Rezoning Transportation Analysis

Petition Number: 2023-155

Date	Description
12-27-23	First Review (IW)

TRINITY PARK TOWNHOMES

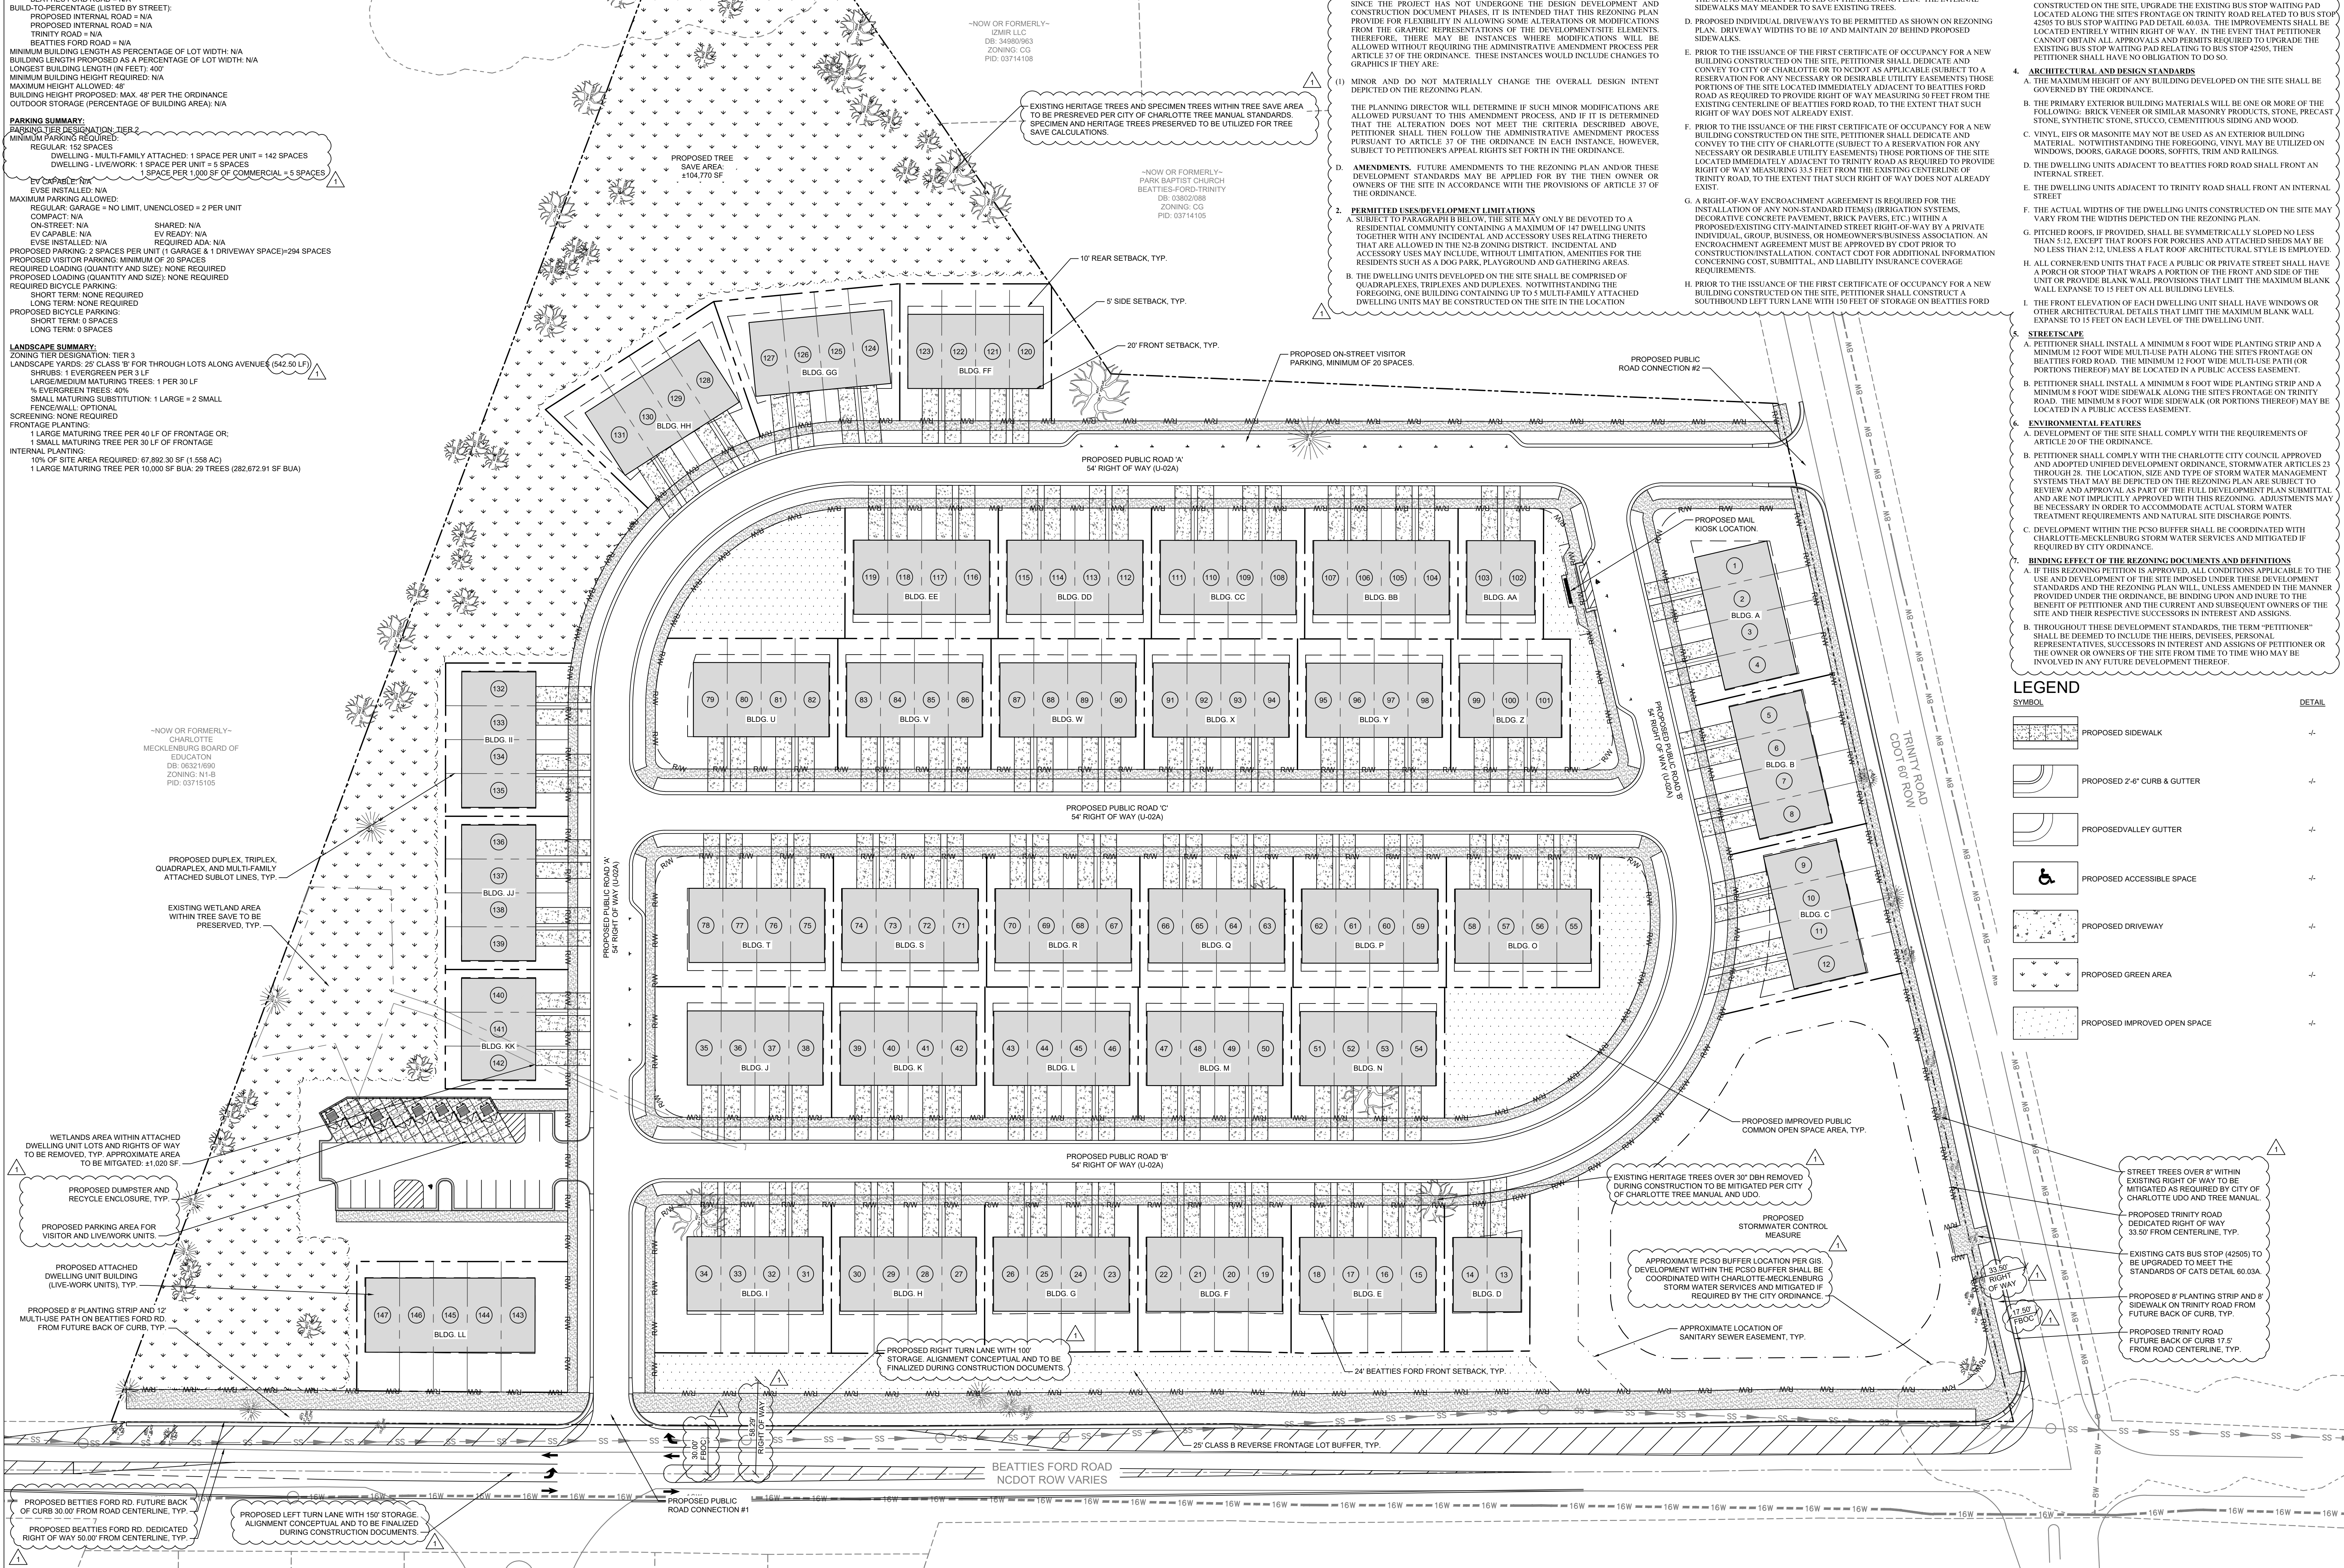
- a. **Beatties Ford Road:** Location of future back of curb and gutter to be constructed 30' from centerline.

- b. **Trinity Road:** Location of future back of curb and gutter to be constructed 17.5' from centerline.

Label and dimension the curb and gutter from the centerline for each road on the site plan.

- 3. Revise site plan and conditional note(s) to commit to dedicate 33.5 feet of right-of-way from the Trinity Road centerline. The site plan shall label and dimension the right-of-way from the road centerline.
- 4. Revise site plan and conditional note(s) to commit to dedicate 50 feet of right-of-way from the Beatties Ford Road centerline. The site plan shall label and dimension the right-of-way from the road centerline.
- 5. Add a conditional note specifying "A Right-of-Way Encroachment Agreement is required for the installation of any non-standard item(s) (irrigation systems, decorative concrete pavement, brick pavers, etc.) within a proposed/existing City-maintained street right-of-way by a private individual,

6. Per coordination with NCDOT, revise site plan and conditional note(s) to commit to constructing a left turn lane with 150' storage on Beatties Ford Road.
7. Per coordination with NCDOT, revise site plan and conditional note(s) to commit to constructing a right turn lane with 100' storage on Beatties Ford Road.
8. Revise site plan and conditional note(s) to commit to designating the residential hammerhead portion of the proposed road to be private. (see snip below)

9. CDOT REQUEST: Revise site plan and conditional note(s) to commit to installing a Left turn lane at the intersection from Beatties Ford onto Trinity Road.
10. CDOT REQUEST: Revise site plan and conditional note(s) to commit to reconfiguring the site so that homes are alley fed which will decrease conflict points on the public road. At minimum, revise site plan to alley feed all units along Public Road 'A' and 'E'.
11. Revise site plan and conditional note(s) to commit to removing conditional note 3.D. as driveways will be reviewed during the permitting process as site specific alternations could change or dictate the specific dimensions needed as shown in the Charlotte Land Development Standards Manual. If petitioner decides to make units accessible by alley, CDOT is comfortable with this note residing.
